## DESIGN BRIEF

SITE PLAN CONTROL

315 + portion of 321 Chapel St, Ottawa,  
ON K1N 7Z2

# 315-321 CHAPEL STREET - ALL SAINTS

drawing title | titre du dessin
**NORTH (LAURIER)
ELEVATION**

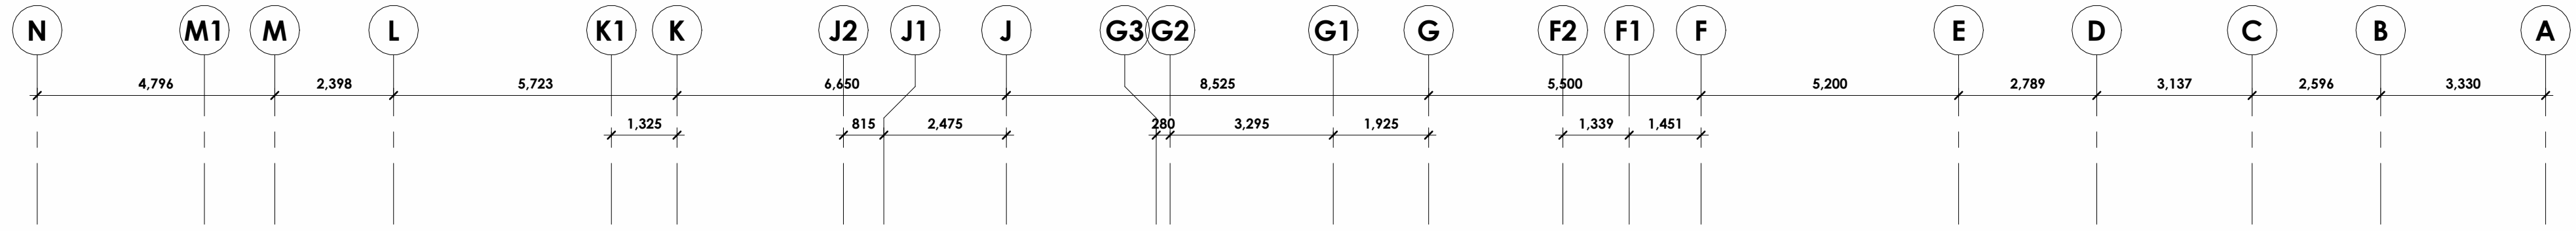
8.10	Ensure that materials are robust enough to provide longevity to the building.	Acknowledged.
8.11	The Panel has concerns with the approach taken to the stairway on the exterior of the building.	The façade has been modified so that the prominence of the exit stair has been removed. It has been blended into the overall north façade by setting back the rooftop stair access from the façade and removing any ornamentation that would draw attention to the stair. The exit doors at the base will be the same finish as the surrounding facade.

8.12	Explore different ways to address the stairway/vertical portion on Laurier Avenue.	The verticality of the stair has been removed - see above response.
<b>9</b>	<b>Site Design &amp; Public Realm</b>

11.13	The Panel strongly recommends extending the brick volume further west along Laurier Avenue to at least 2/3 of the building façade rather than 1/3. The masonry provides a complementary contrast with the stone church and an elegant design solution.	I believe more clarification would be required to understand this comment fully. If the intent is to extend the brick volume to the West, that will increase the building footprint. If that is the intent of the comment, we will definitely consider it. If the intent is to only extend the brick finish, we intended that section of the North facade, beside the church, to allow for more transparency to the apse (all the glazing).

**1 FLOOR PLAN - LEVEL 01**  
A2-101 1:100

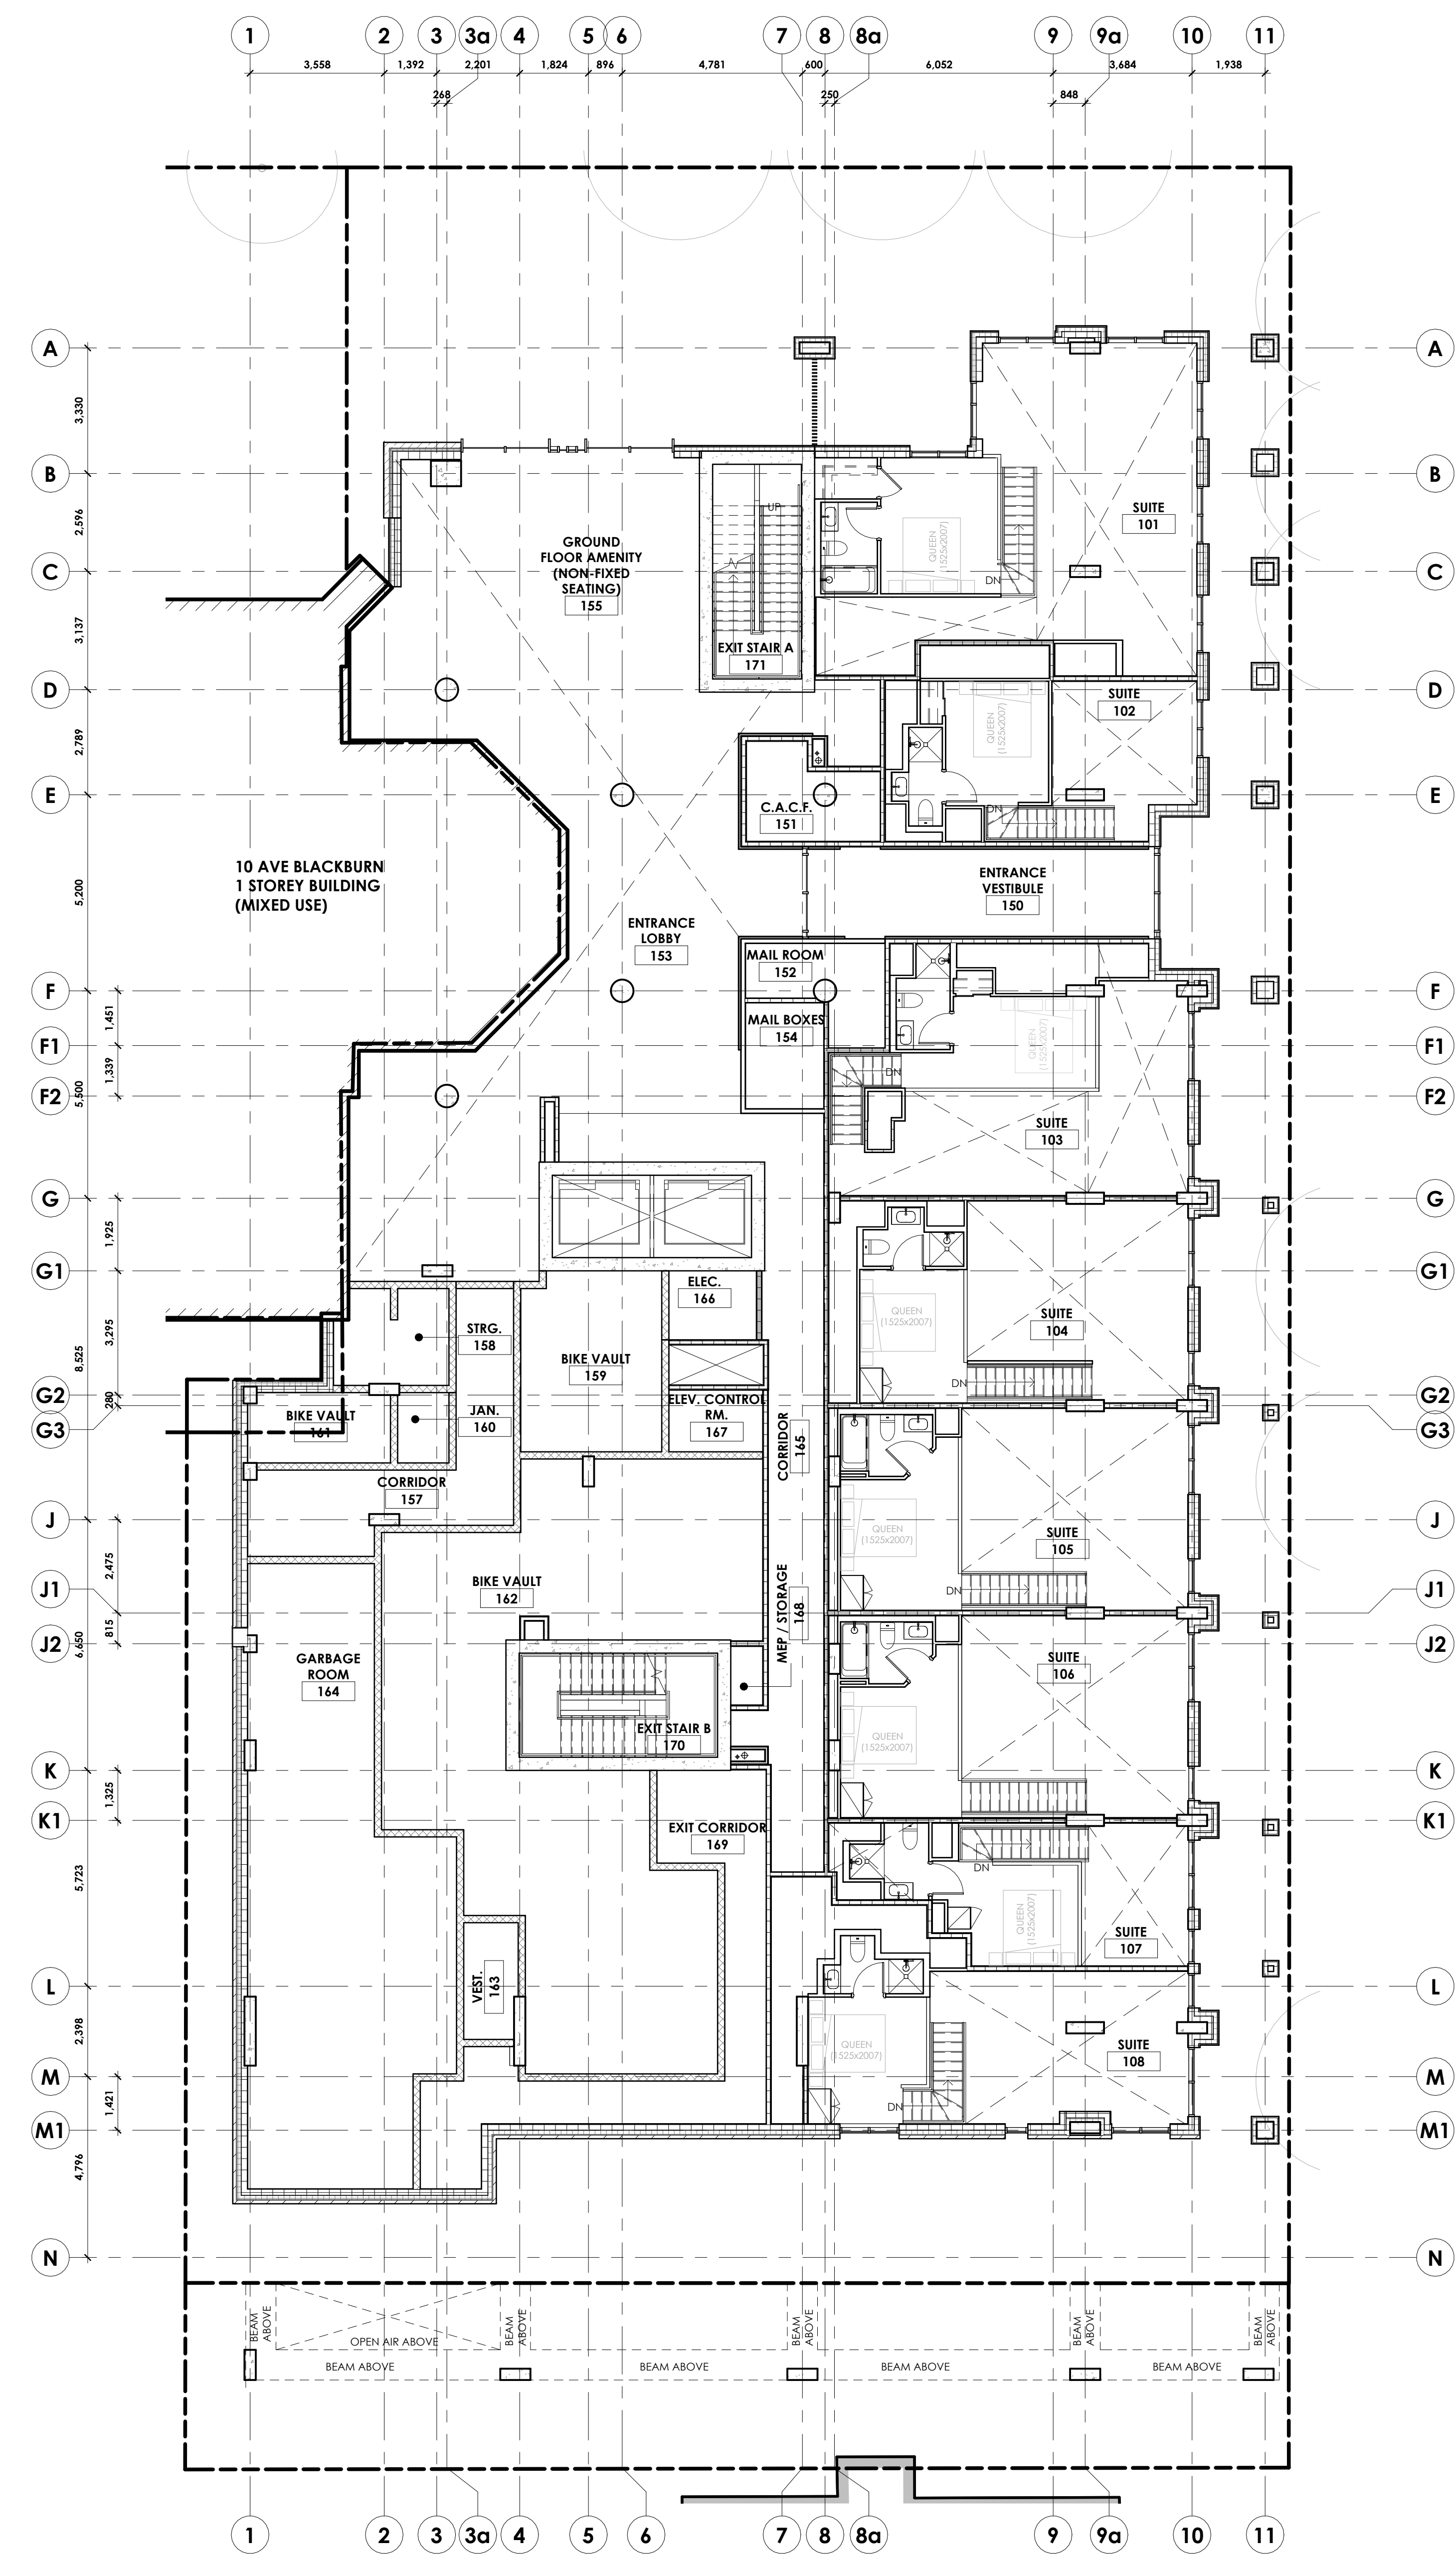
3	<p><b>North Façade (Laurier Avenue East)</b></p> <ul style="list-style-type: none"> <li>• While we have no concerns with the main entrance being located along Blackburn Avenue, please ensure that the Laurier façade and its entrance(s) remain(s) active. Currently the stairway occupies space that can otherwise provide a better relationship with the street, obstructs the visibility of the apse, and restricts unified fenestration of the northern façade. Consider other location for the stairway, reconfiguration for the visitor bicycle parking rack, and opening the corner portion of the ground floor for continuous visibility of the apse along Laurier Avenue from the east. Laurier Avenue East is defined as a minor corridor in the Official Plan: On Downtown Core Minor Corridors, all buildings shall have active entrances facing the Minor Corridor, regardless of use. (Policy 4 in Section 5.1.4).</li> </ul>	<p>The apse will be completely visible from Laurier (save the roof which must be enclosed to maintain the firewall between the two structures).</p> <p>An active entrance to Laurier Avenue is provided, with an entrance to the lobby and amenity area provided via the Laurier frontage. Given Laurier Avenue is a major pedestrian route, we anticipate that this entrance will be well-used by both guests and residents.</p> <p>Exterior bicycle parking has been re-arranged; the bicycle parking rack has been downsized and five (5) convenient bicycle parking spaces are now provided at each of the lobby entrances.</p> <p>The visitor bicycle parking is being rearranged to be more welcoming on this facade. There is no other practical location for the stairway considering the required setbacks in the building in coordination with the parking garage (the stair either ends up in a setback or in the drive aisle).</p>
